**Comment Letter for Proposed Redevelopment of 6950 SE Maker Street, Permit 2207-019**

My name is Dan Grove and I live at 3515 72nd Ave SE. I'm writing as a concerned neighbor who shares a property boundary with the proposed development (submission documents [here](#)) at 6950 Maker Street ("The Project", owned by The Strand Trust). As a long-time member of the Mercer Island community, I was surprised and dismayed to see a proposal for a house much larger than permitted by code, a house built to a height of 34+' on top of an artificially elevated lot, a house that would be built on a lot with a history of rockery problems and a house whose development was enabled by significantly damaging an exceptional tree. That this proposal was submitted without any discussion with neighbors of the property makes it even more troubling.

GRADING, DRAINAGE AND UTILITY PLAN  
FOR  
**STRAND PROPERTY**  
6950 SE MAKER ST., CITY OF MERCER ISLAND KING COUNTY, WASHINGTON

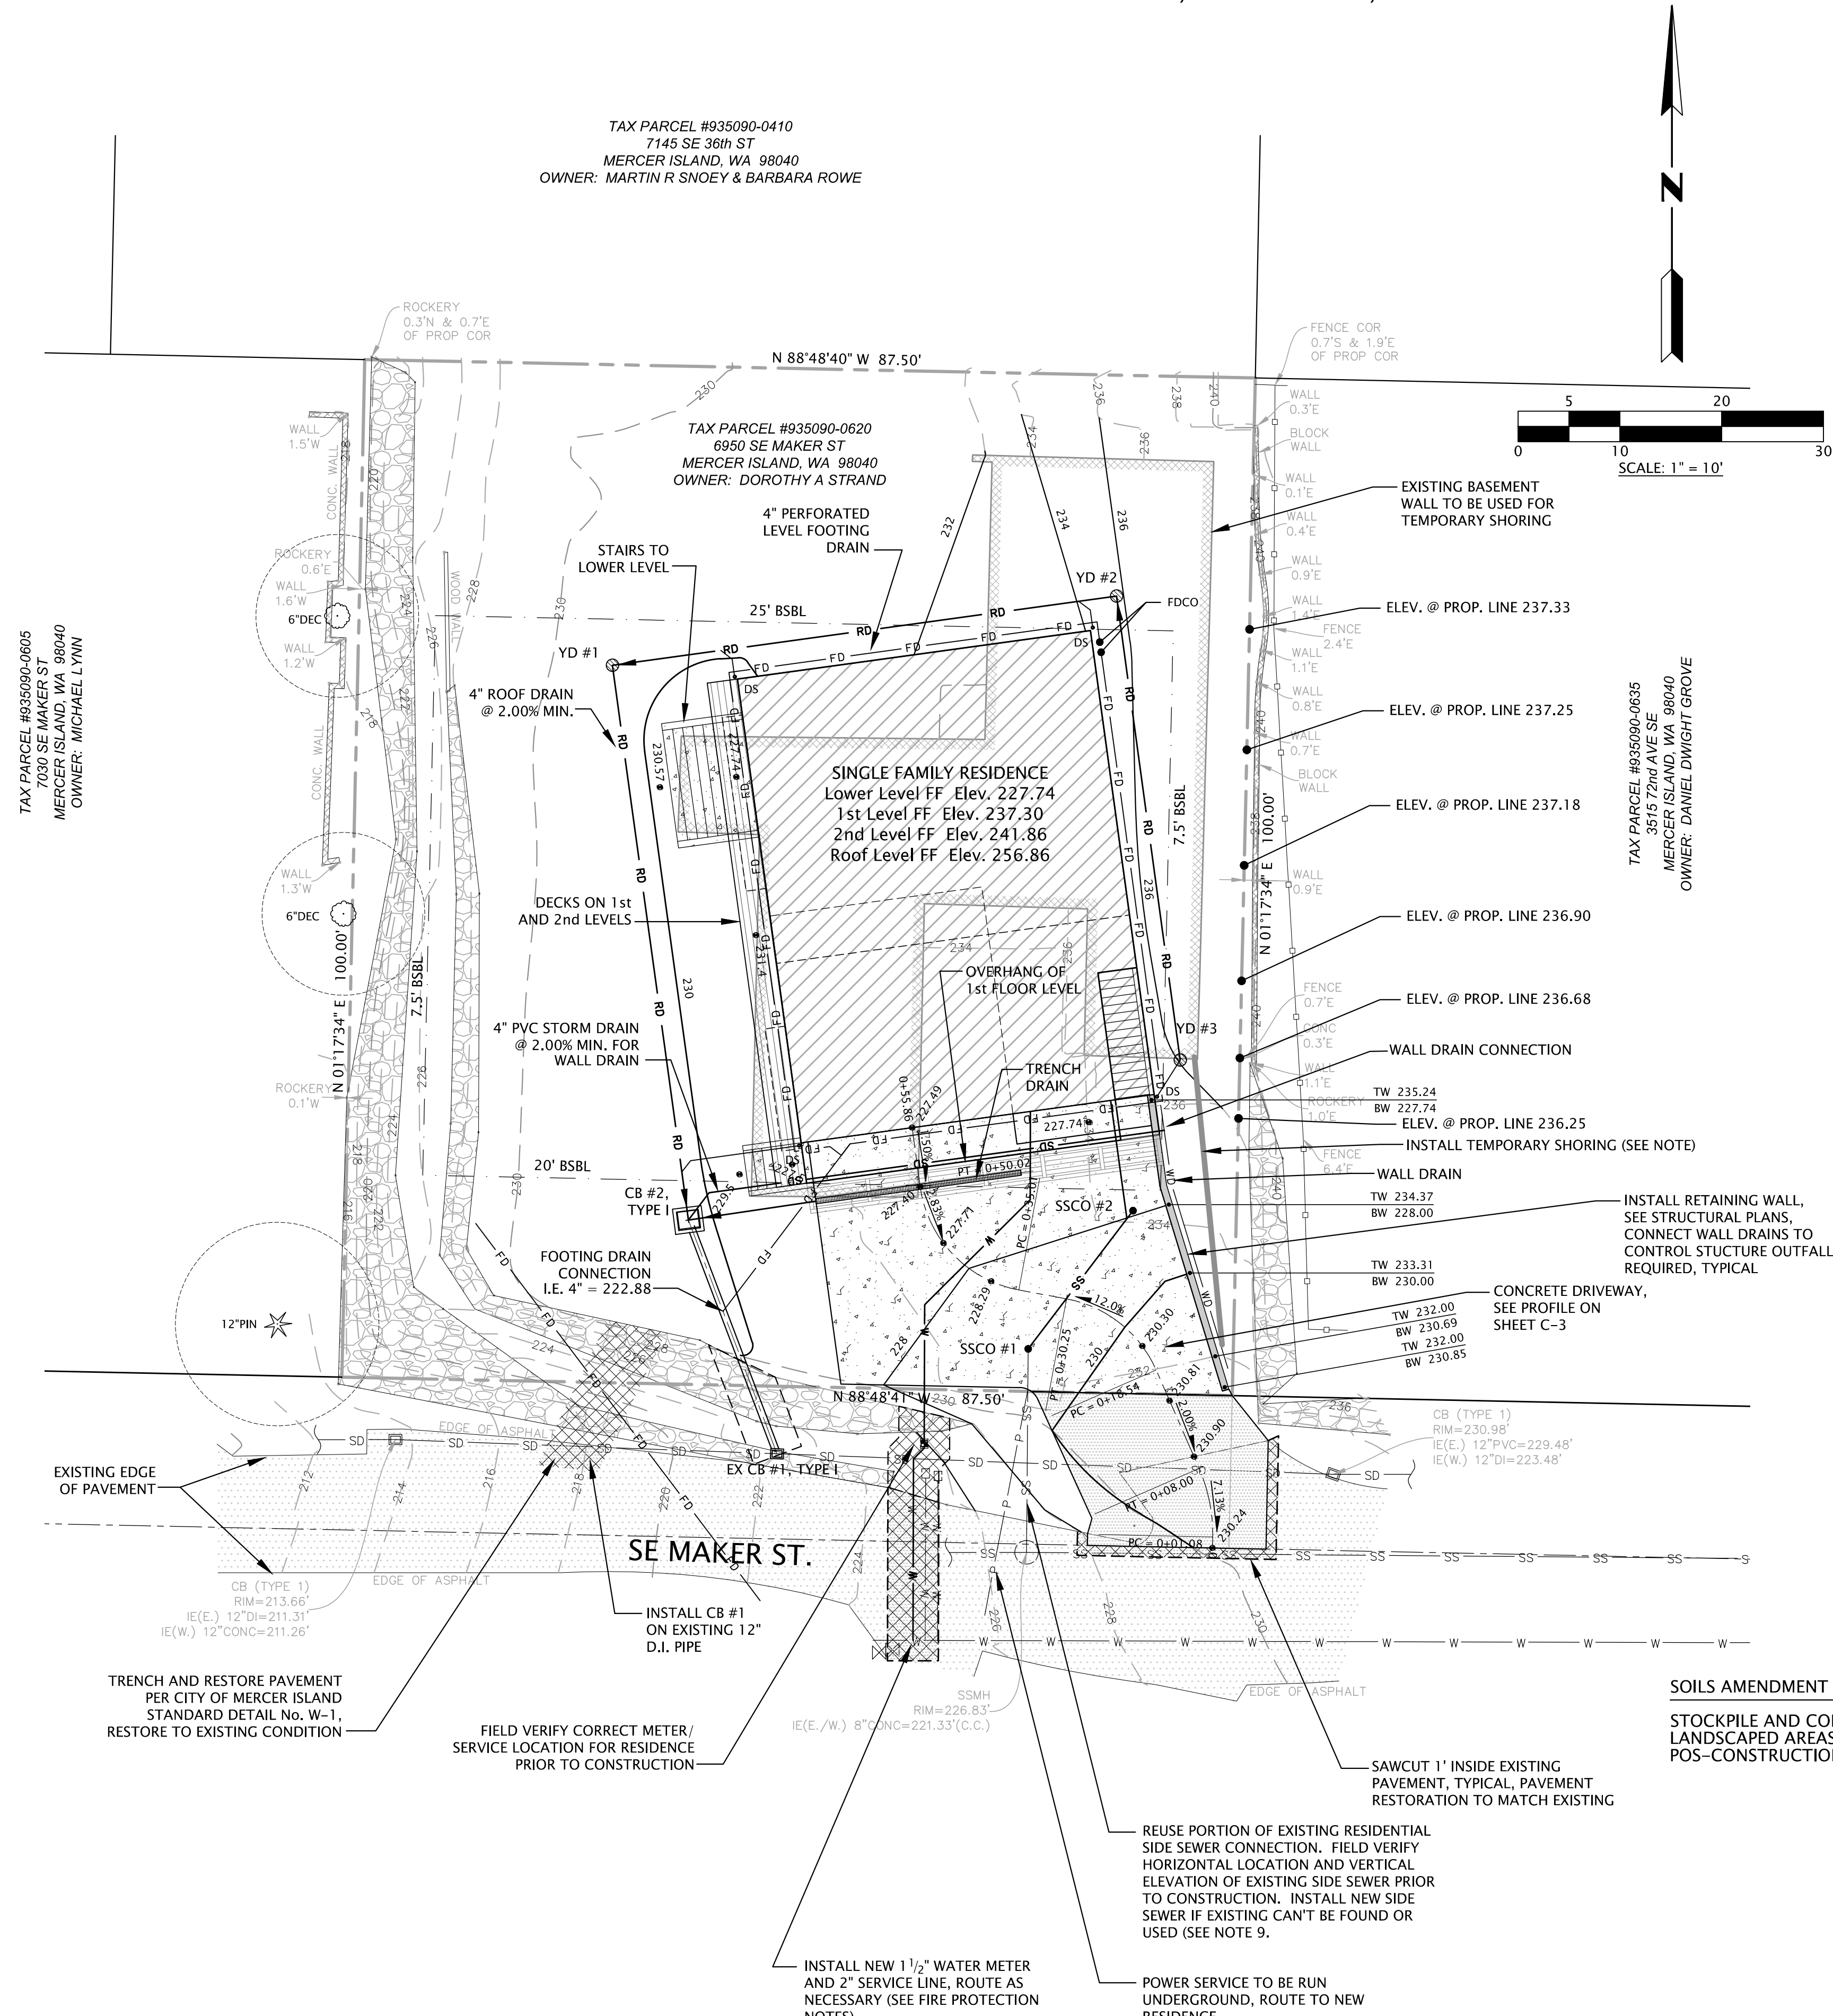
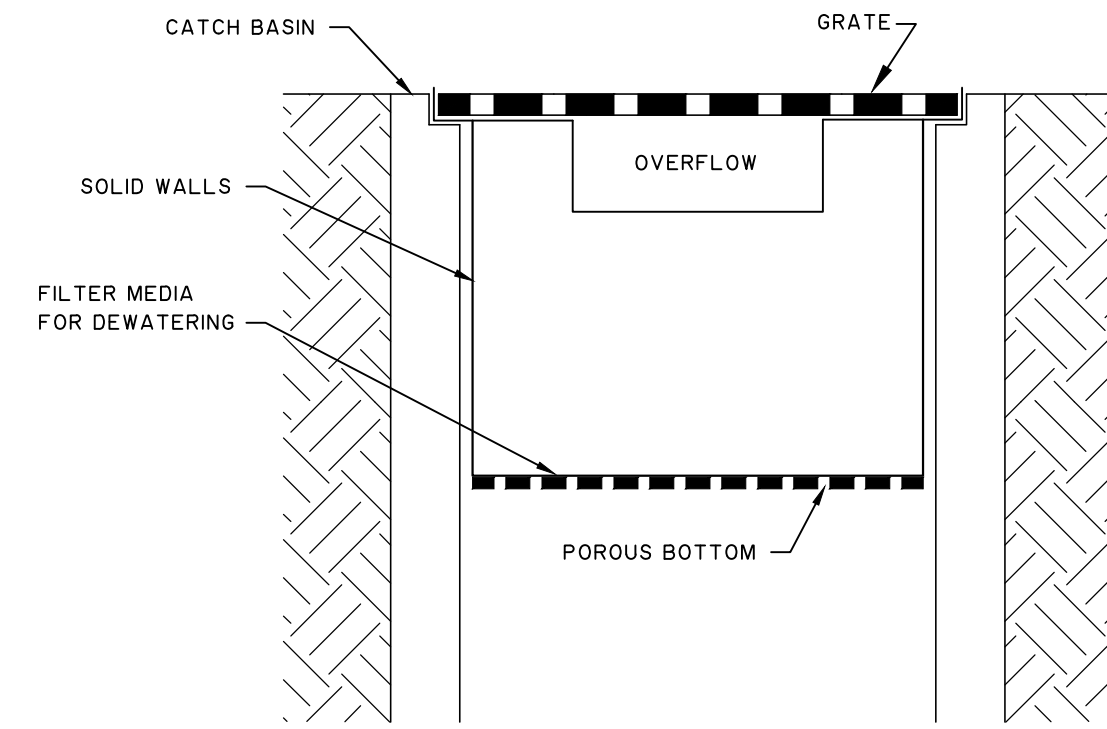
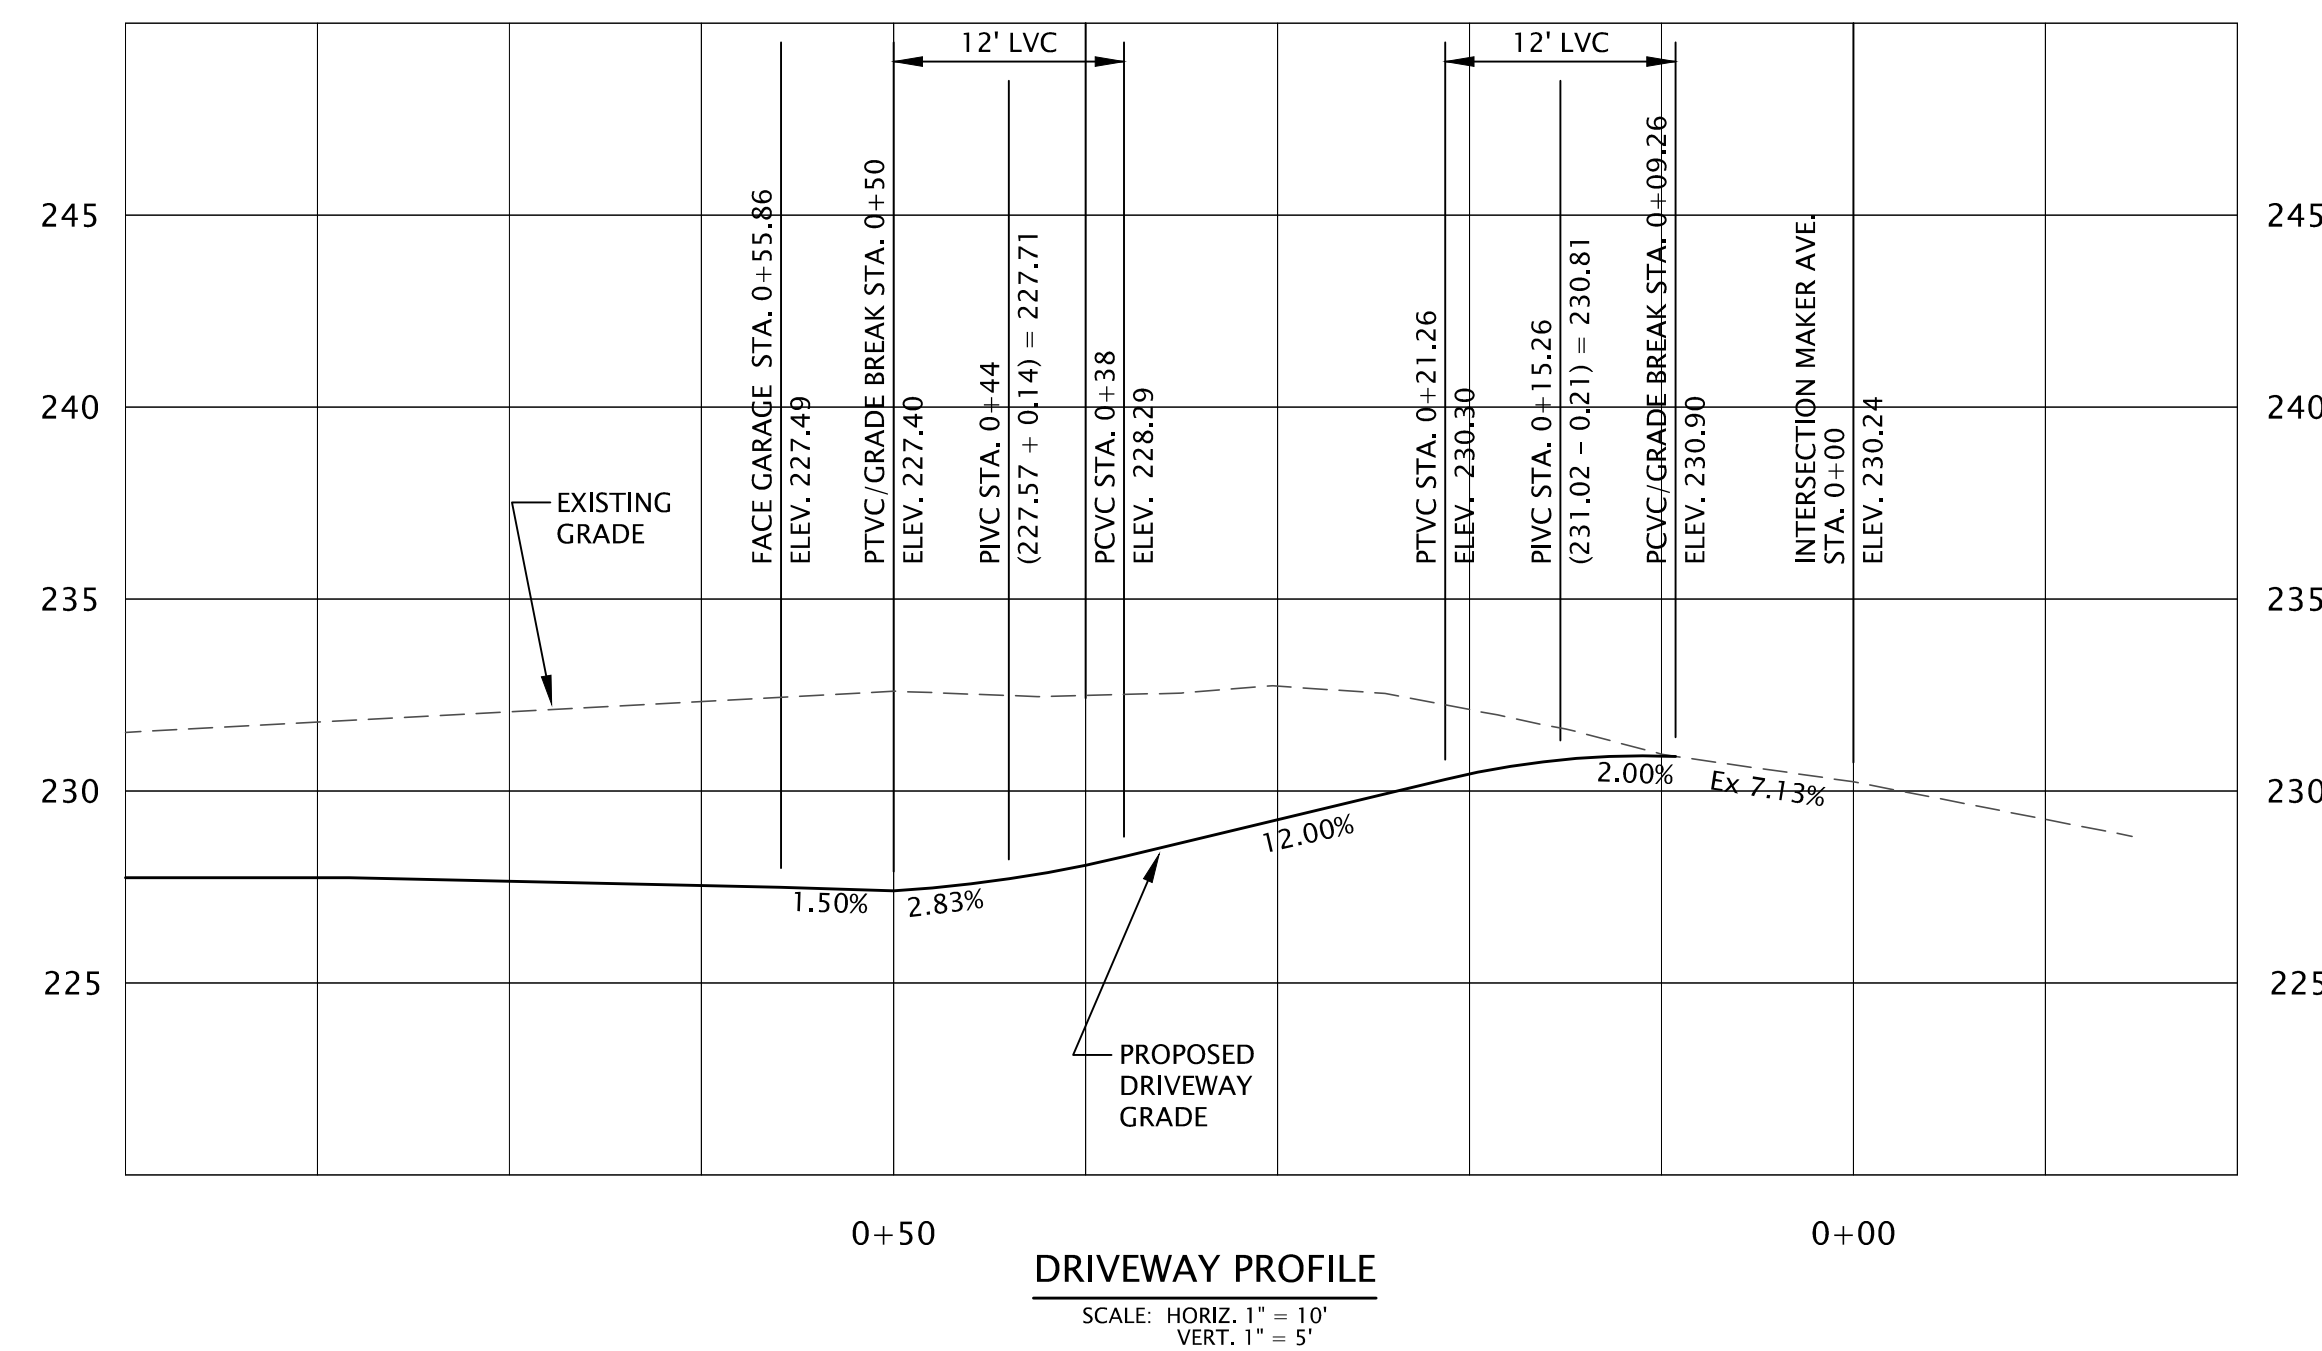
I request that the City of Mercer Island require an approved shoring plan for the eastern side of this project prior to any demolition of the existing structure. In addition, given the risks outlined, the Applicant should be required to hire a geotech engineer for a new survey tailored to her actual building aspirations (beyond the current house’s existing footprint) as well as for regular inspections of the eastern side of the site.
